**SUBJECT: SFD2205-0065**  
**SINGLE FAMILY DWELLING**

Here are the results of all Inspections located at **159 HAY FIELD DR:**

Job 22030102-A	Truss A02	Truss Type Piggyback Base	Qty 4	Ply 1	100 Farm at Neills Creek-Cooper 4-Roof	I57729103
					Job Reference (optional)

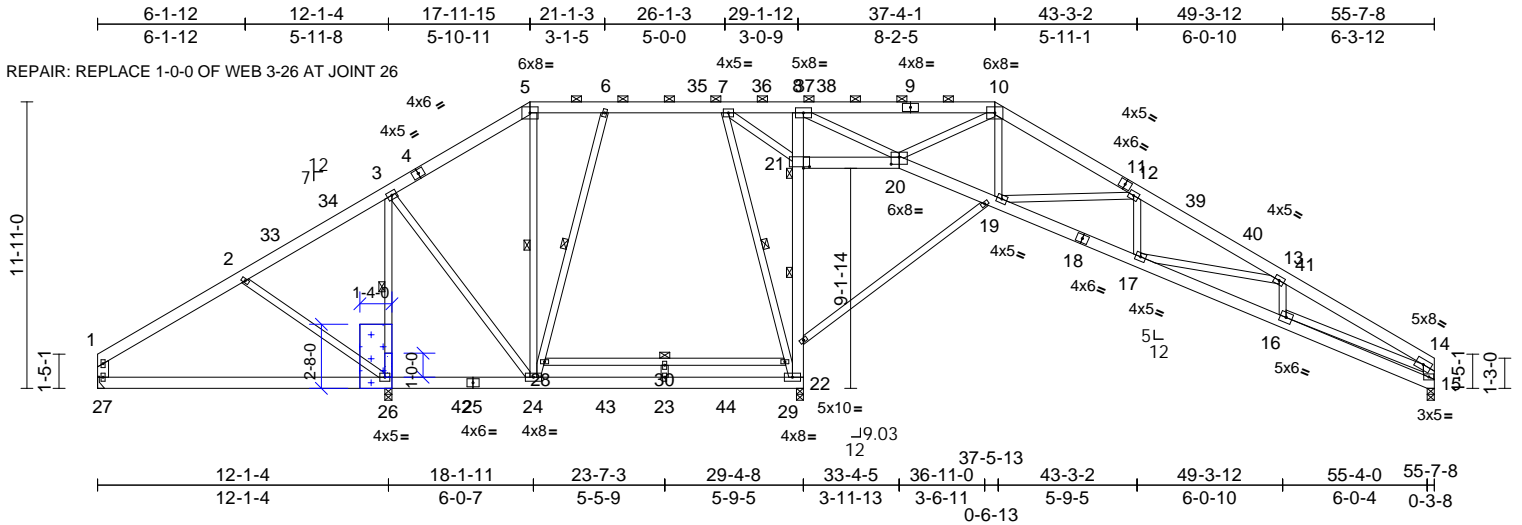
Inspection Type: FINAL SFD MONO\*\*  
Scheduled Date/Time: 4/10/2023  
Completed Date/Time: 4/10/2023  
Inspector: Justin Ryan McLeod  
Result: DISAPPROVED  
Remarks:  
Notes: Truss broke at attic access, need repair
